# KITTITAS COUNTY COMMUNITY DEVELOPMENT SERVICES

Subject: Rucker Boundary Line Adjustment (BL-15-00005)

On May 22, 2015 Kittitas County Community Development Services (CDS) received your application for the above Boundary Line adjustment Permit (BL-15-00005). The application as submitted has been deemed **incomplete** by CDS until such time as the following are submitted:

**BOUNDARY LINE ADJUSTMENT**

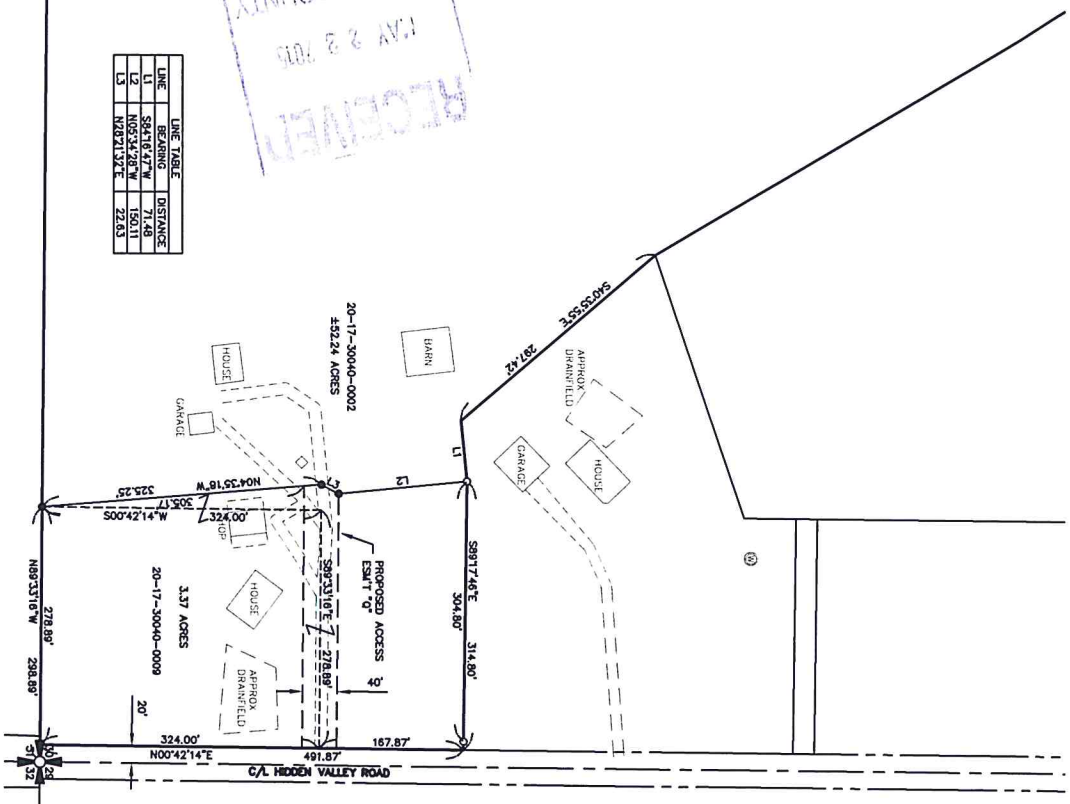
- *Scaled site plan encompassing all parcels involved in the boundary line adjustment. You have submitted a site plan with all of parcel 20-17-30040-0009 and part of parcel 20-17-30040-0002.*
